BCA ASSESSMENT REPORT

**Aspect Industrial Estate
Lots 54-58 Mamre Road, Kemps Creek
Warehouse 9 (Lot 9)**

**Prepared For:
Mirvac**

Date: 09 June 2022

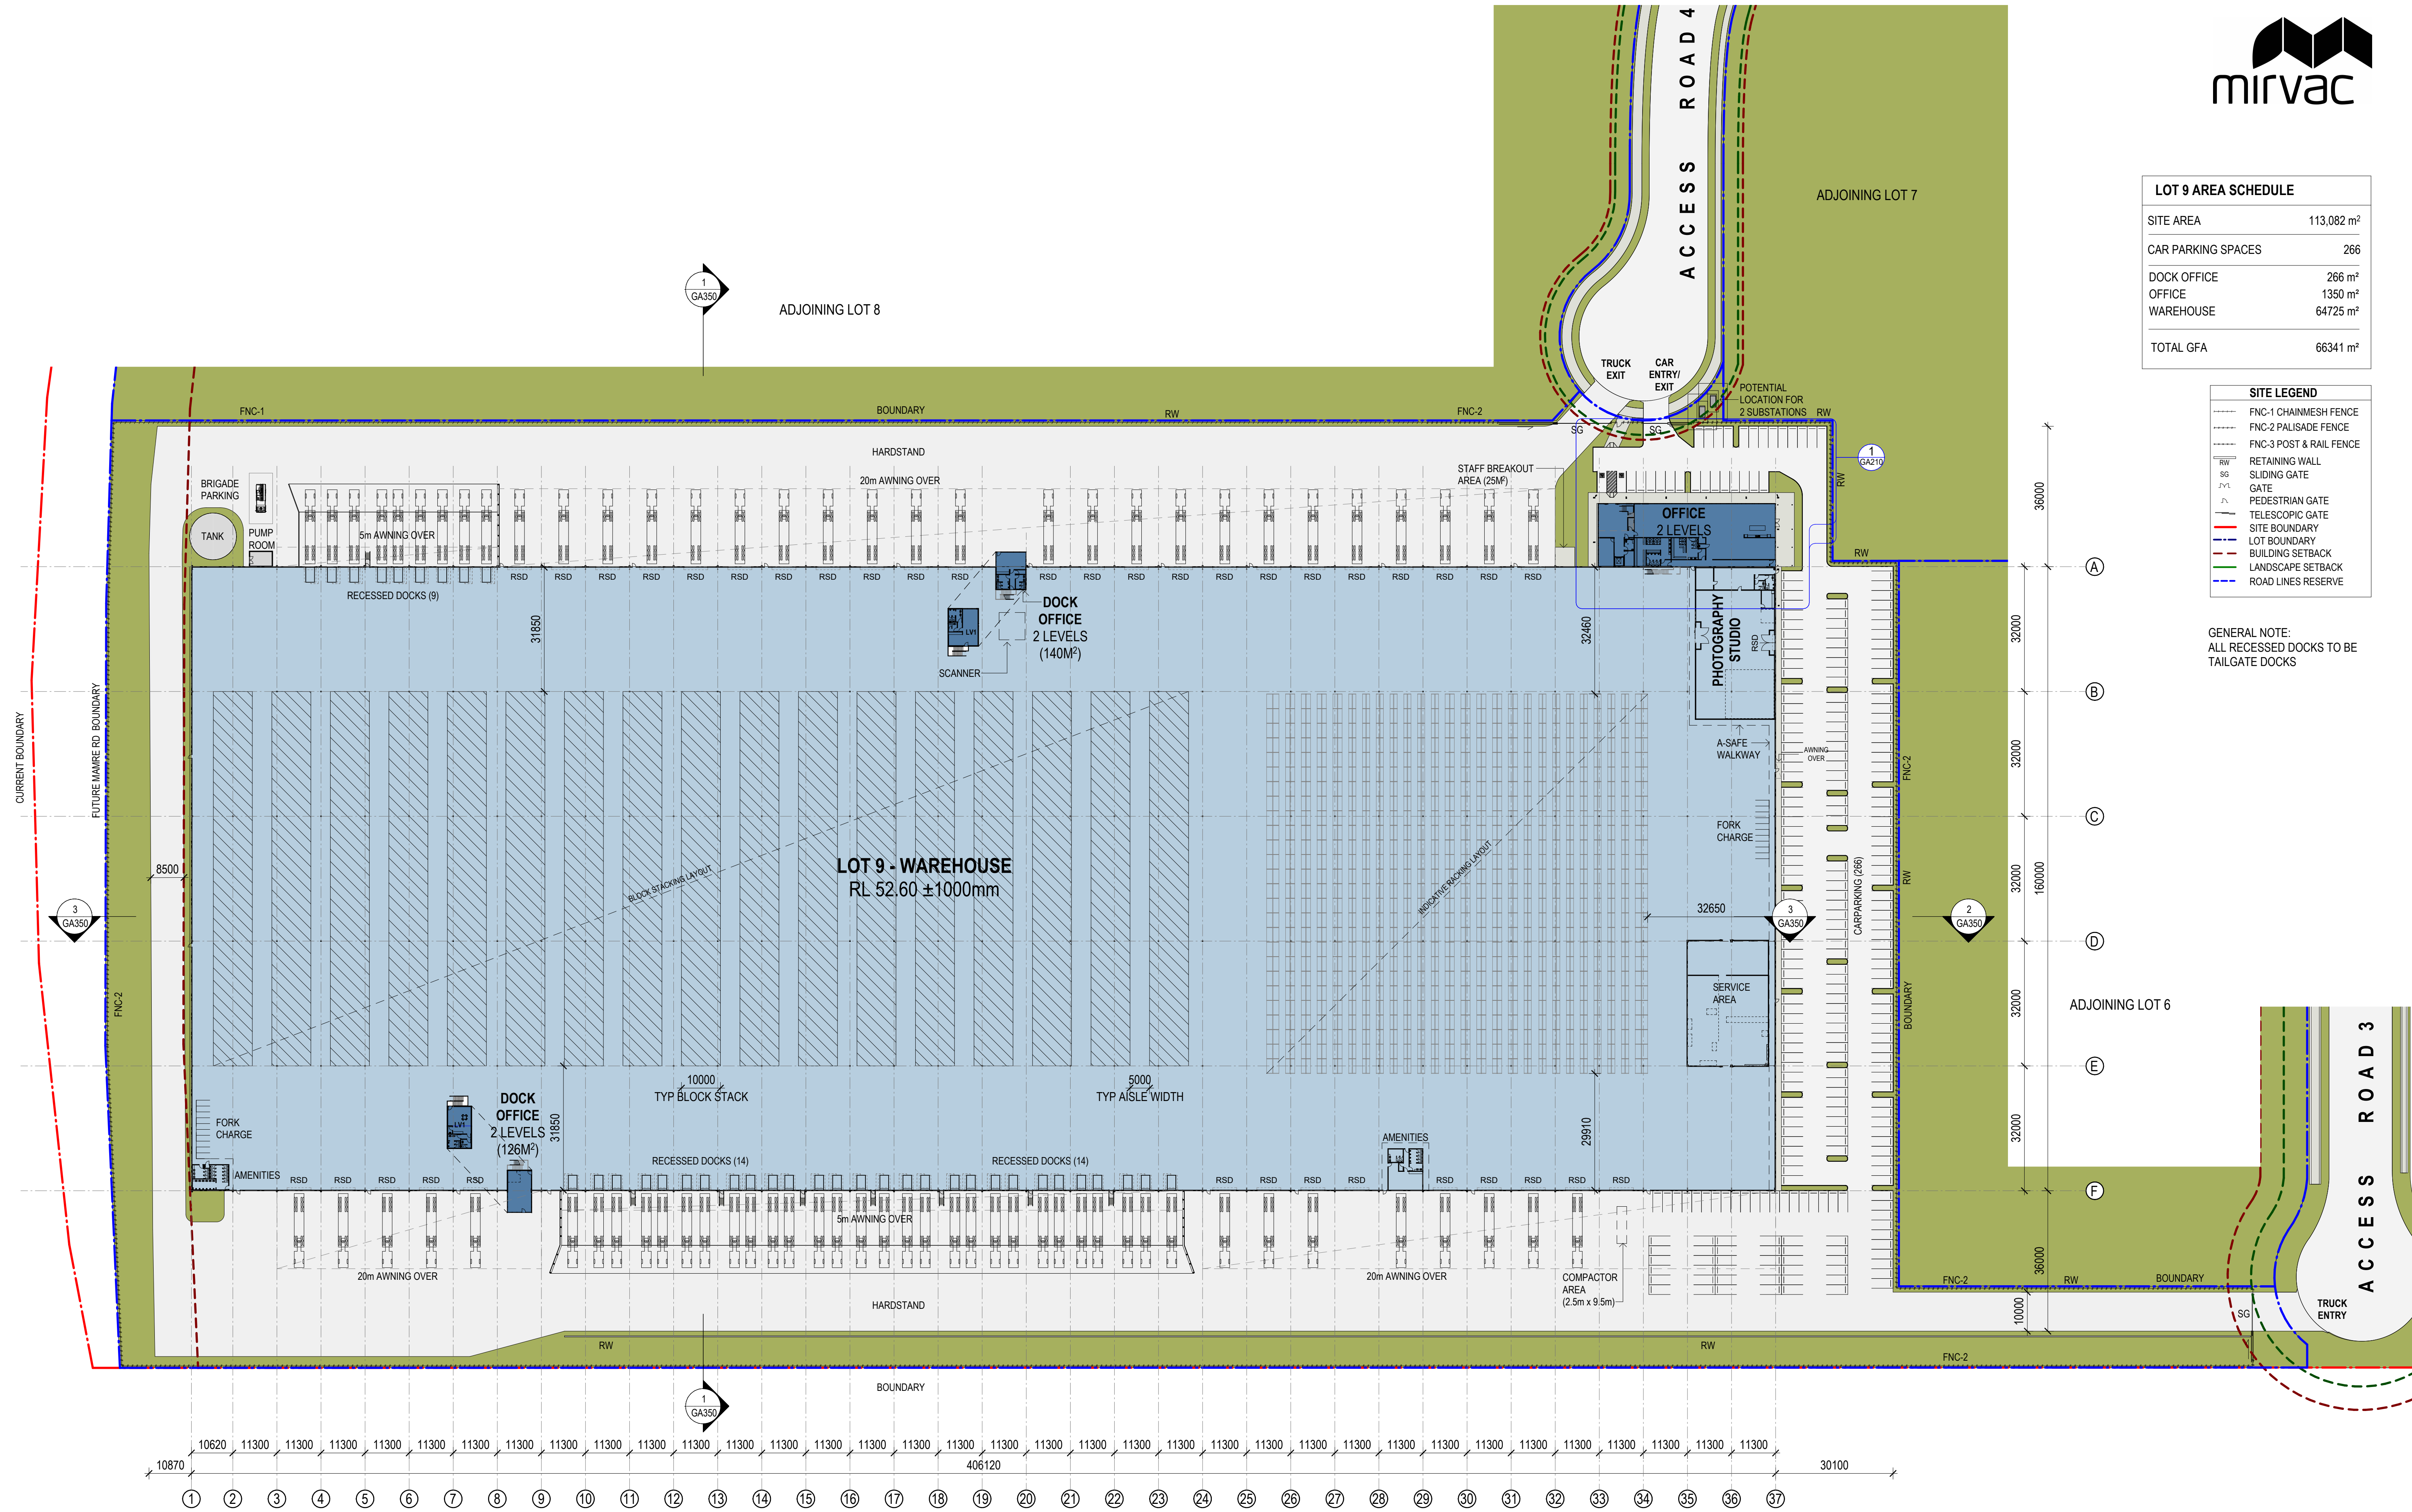
Comments: The proposed building does not comply with the provisions of C2.4 and thus the following non-compliance issues are required to be addressed as a Performance Solution by the Fire Engineer to demonstrate compliance with Performance Requirement CP9:

- + Perimeter Vehicular Access is greater than 18m from various parts of the building identified in red below.

Note 1: Any proposed gates are to achieve no less than 6m unobstructed width or the reduced width will need to be included in the above Performance Solution.

Note 2: The driveways providing vehicular perimeter access must be designed with adequate loading capacities to withstand a fire truck and the gradients of any ramps and swept paths should take into consideration the requirements of the FRNSW Fire Safety Guideline – Access for Fire Brigade Vehicles and Firefighters. Particular attention is drawn to the 90° turn that is required in the NE corner of the carpark.
